Date 8th June 2020

RE: Land at Dappers Lane Angmering

Thank you for your correspondence of the 26th May 2020, advising me of a planning application for 84 No. dwellings, public open space, play areas, associated infrastructure & landscaping. This application affects a Right of Way for which you seek advice from a crime prevention viewpoint.

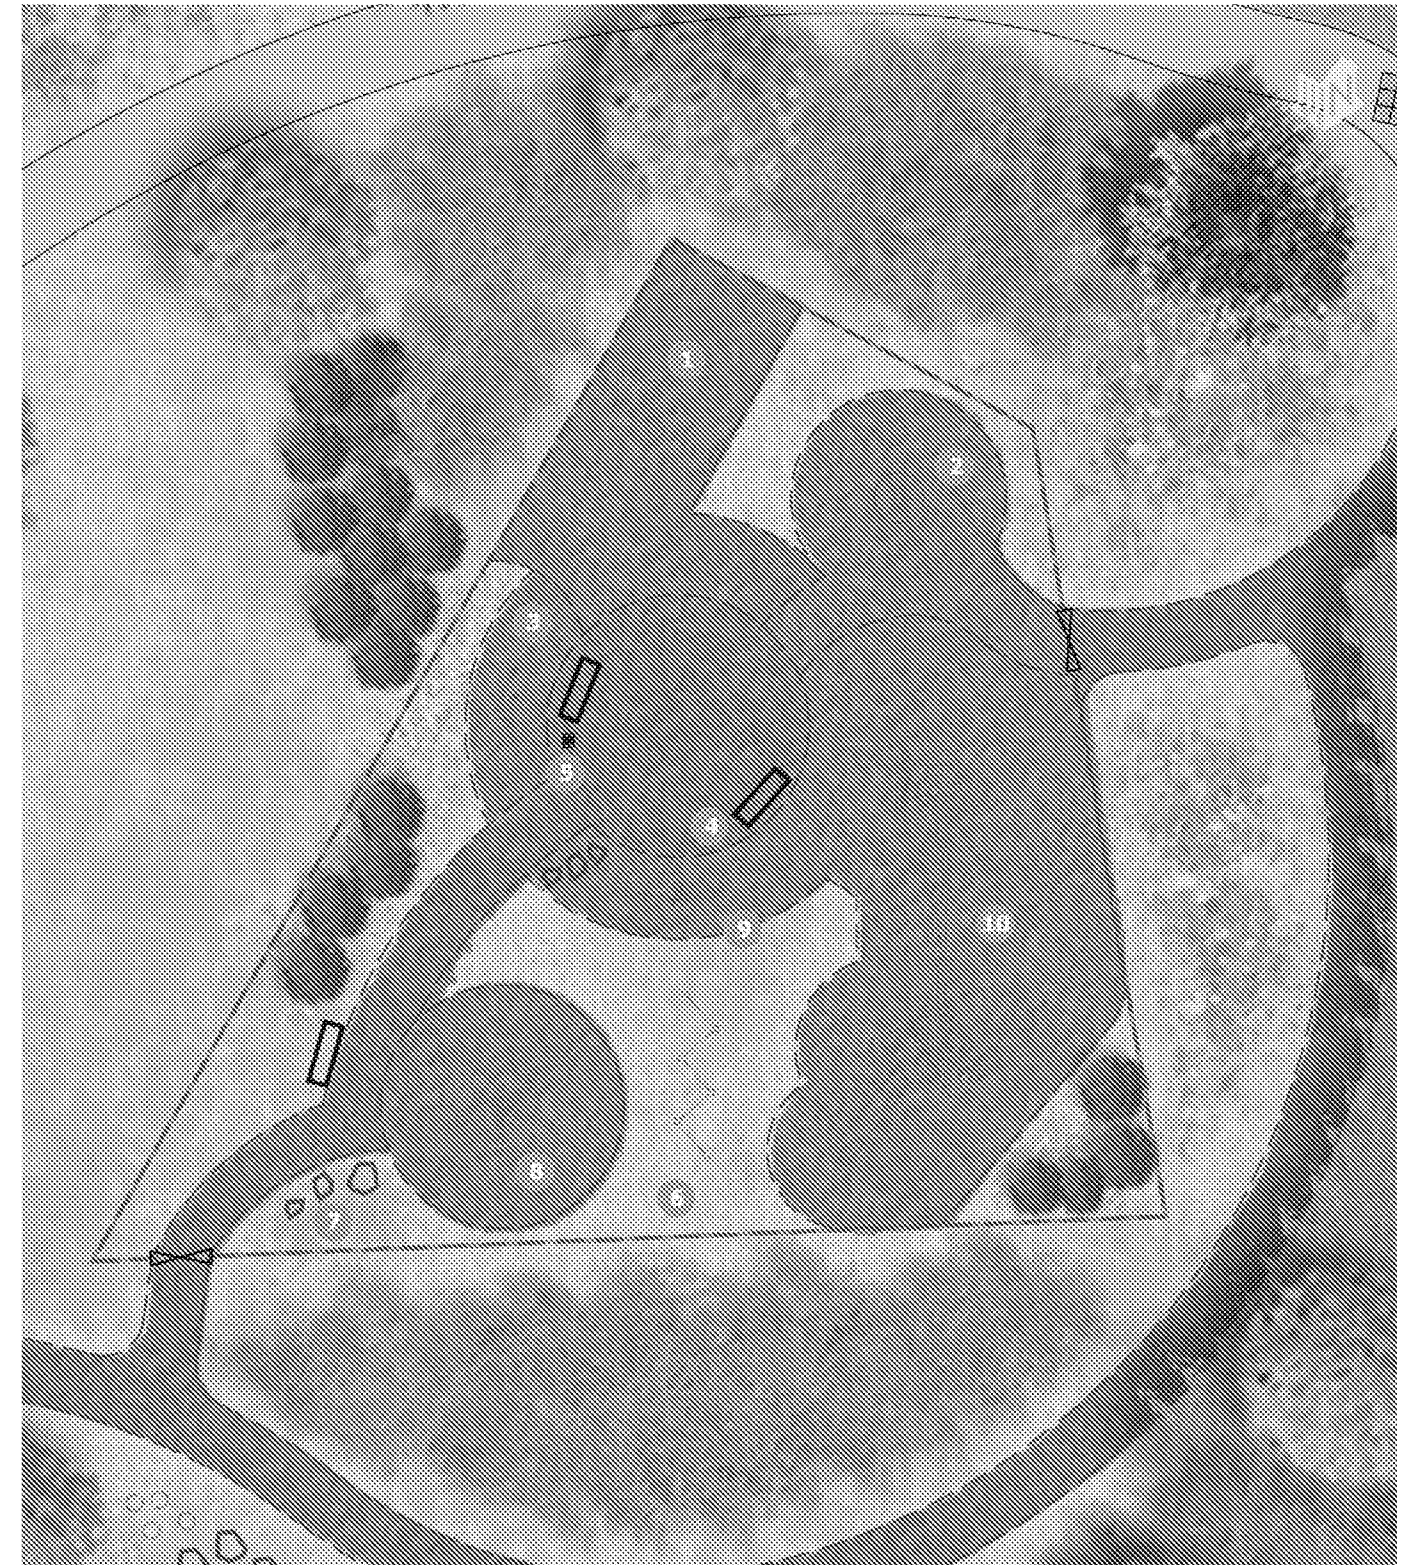
With regards to the proposed LEAP - areas of play should be situated in an environment that is stimulating and safe for all children, be overlooked with good natural surveillance to ensure the safety of users and the protection of equipment, which can be vulnerable to misuse. They should be designed to allow natural surveillance from nearby dwellings with safe and accessible routes for users to come and go. Boundaries between public and private space should be clearly defined and open spaces must have features which prevent unauthorised vehicular access. I would ask that when consideration is given to the eventual location for the LEAP, that it is surrounded with railings with self-closing gates to provide a dog free environment rather than the proposed post and rail fencing with netting.
